CITY OF ALBUQUERQUE

**RE: Savio Ridge Subdivision
9601 Tierra Pintada NW
Grading and Drainage Plan and Drainage Report
Engineer's Stamp Date: 01/24/25
Hydrology File: J08D003B
Case # HYDR-2025-00009**

ZONE MAP NO.
J-07-Z, J-08-Z
CITY PROJECT NO.
—
SHEET NO. 1 OF 9

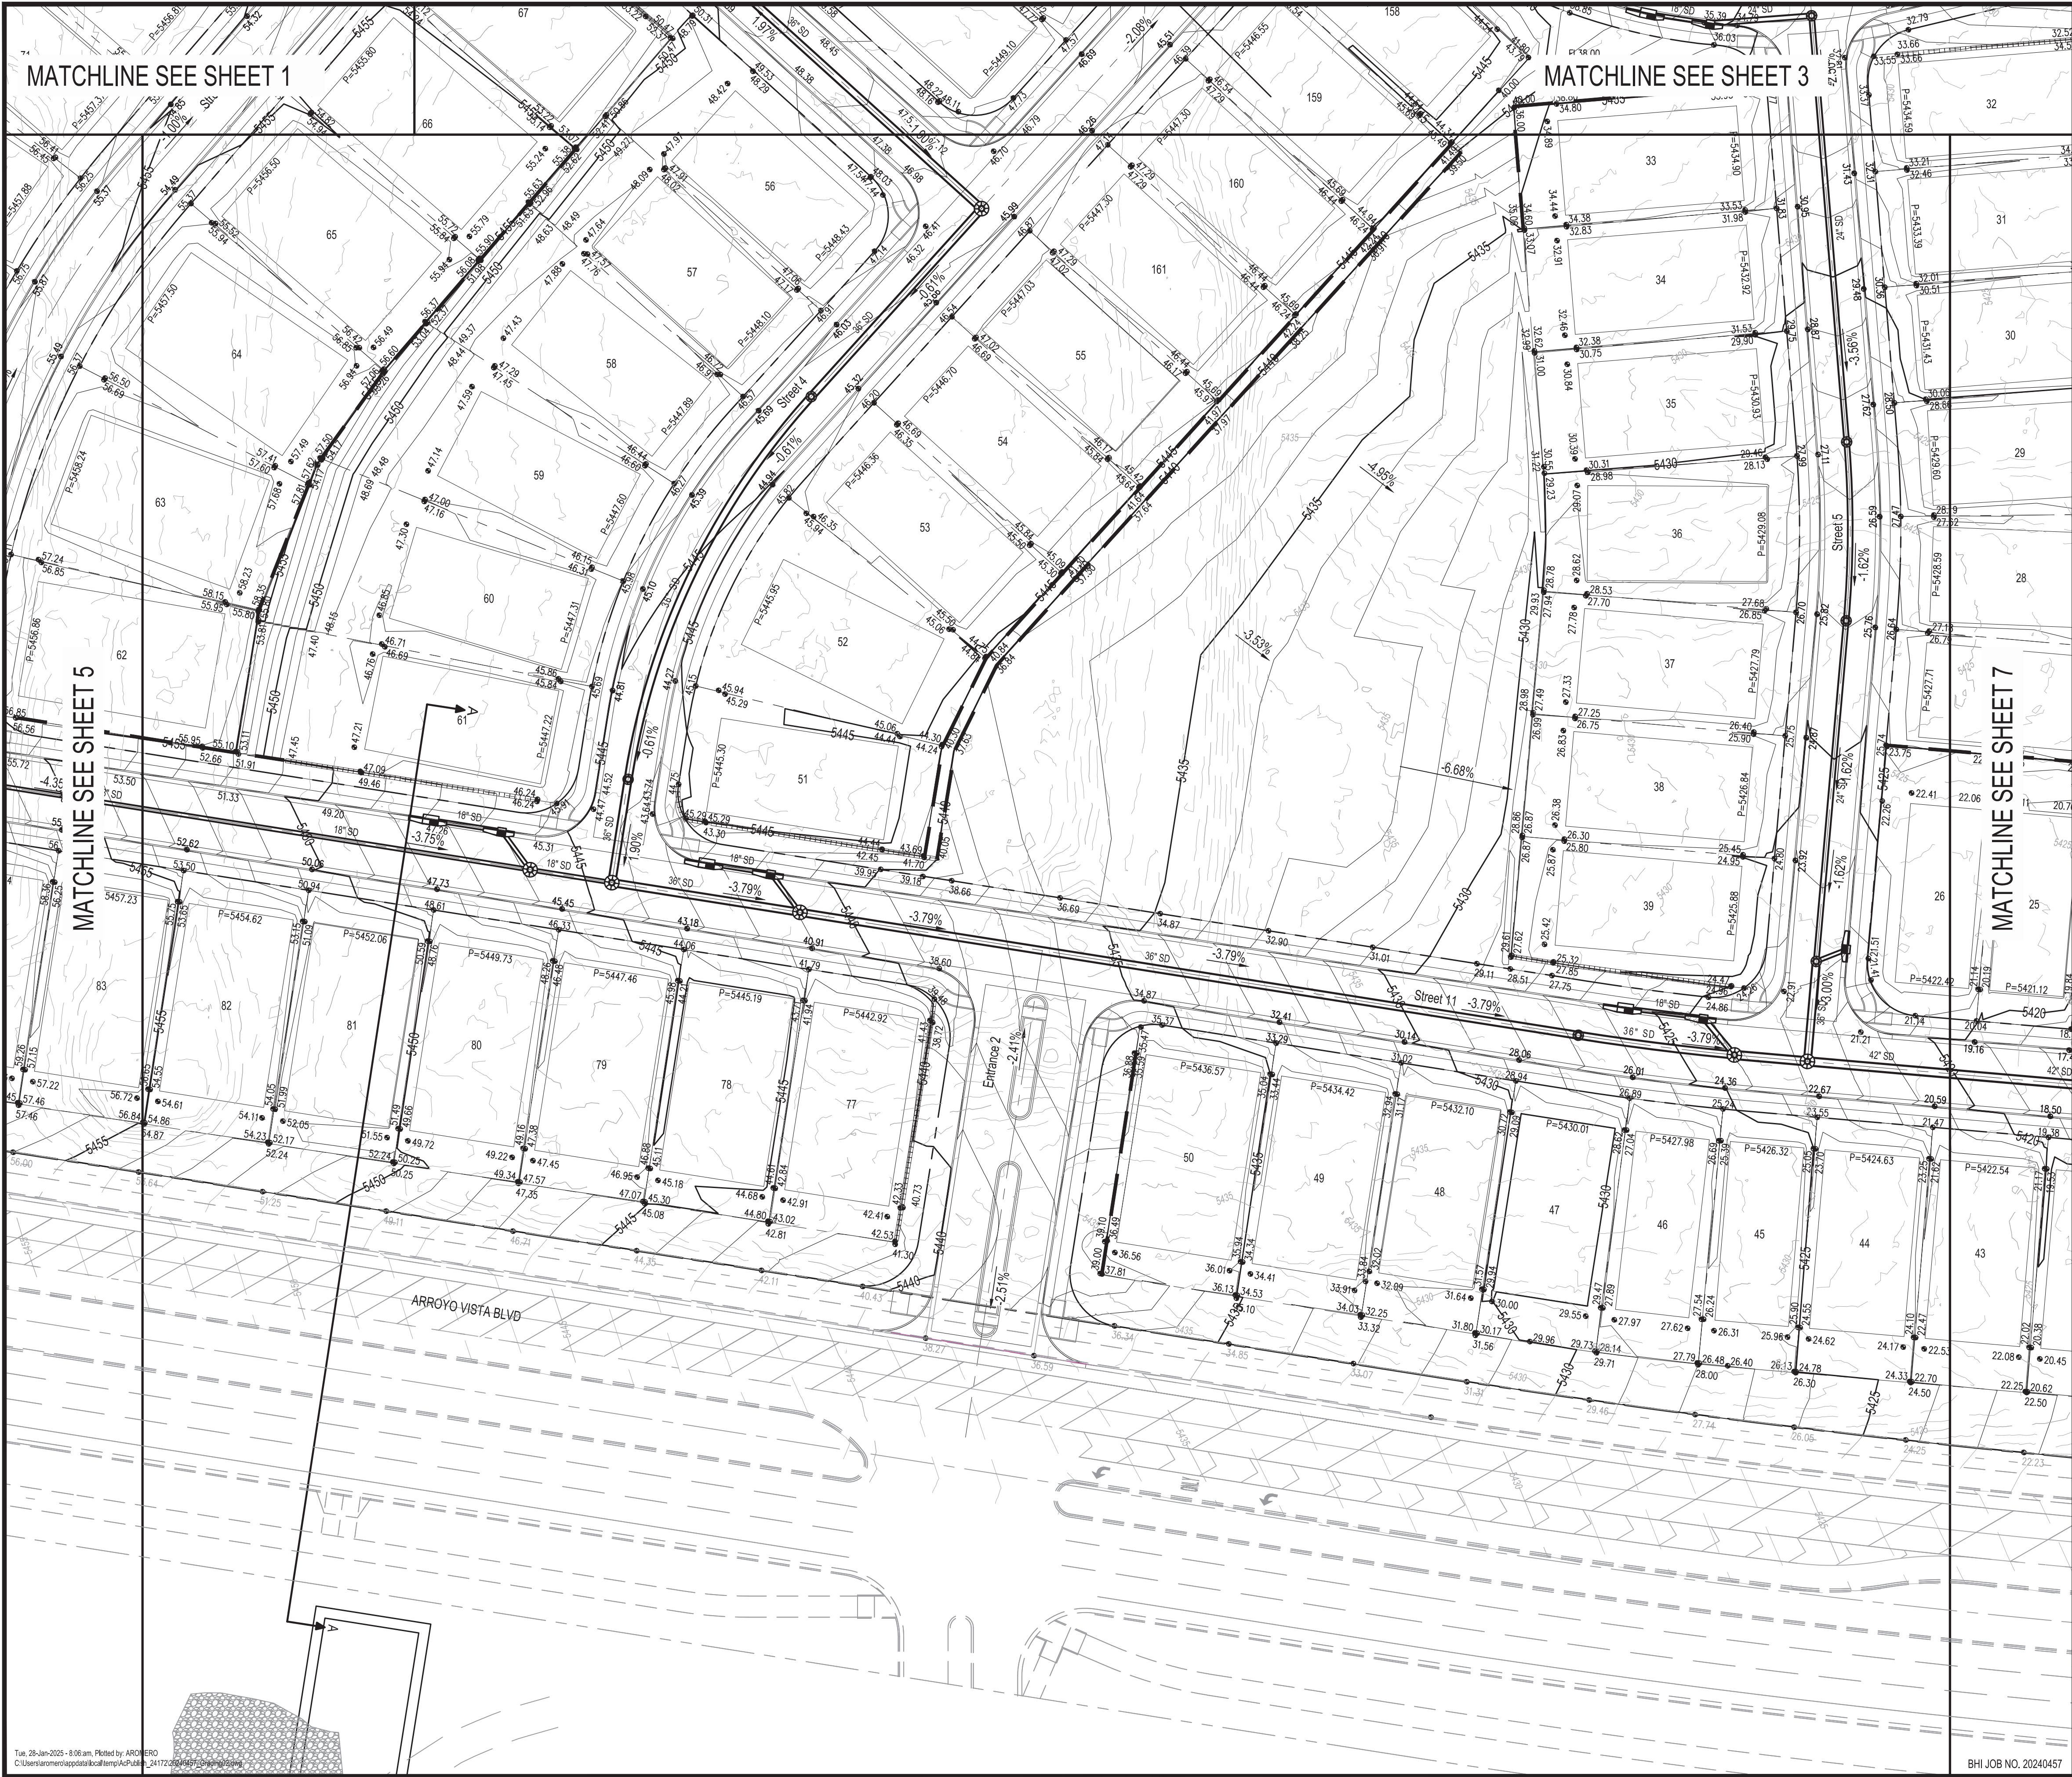
1. Please add the following to the Conceptual Grading and Drainage Plan: "The City of Albuquerque Standard Specifications for Public Works Construction (City Standard Specifications) Section 1014 'Sensitive Lands Preservation and Construction Mitigation' outlines the actions that are required prior to grubbing or grading a site and the additional actions required during the entire span of construction to preserve lands identified for permanent preservation. These requirements shall be consistently applied for the purpose of preserving sensitive land features that are irreplaceable and are essential to the cultural and natural resource heritage of Albuquerque."
2. Please add a section to the Drainage Analysis that discusses Sensitive Lands Preservation and Construction Mitigation as it relates to this site and Standard Specification 1014.
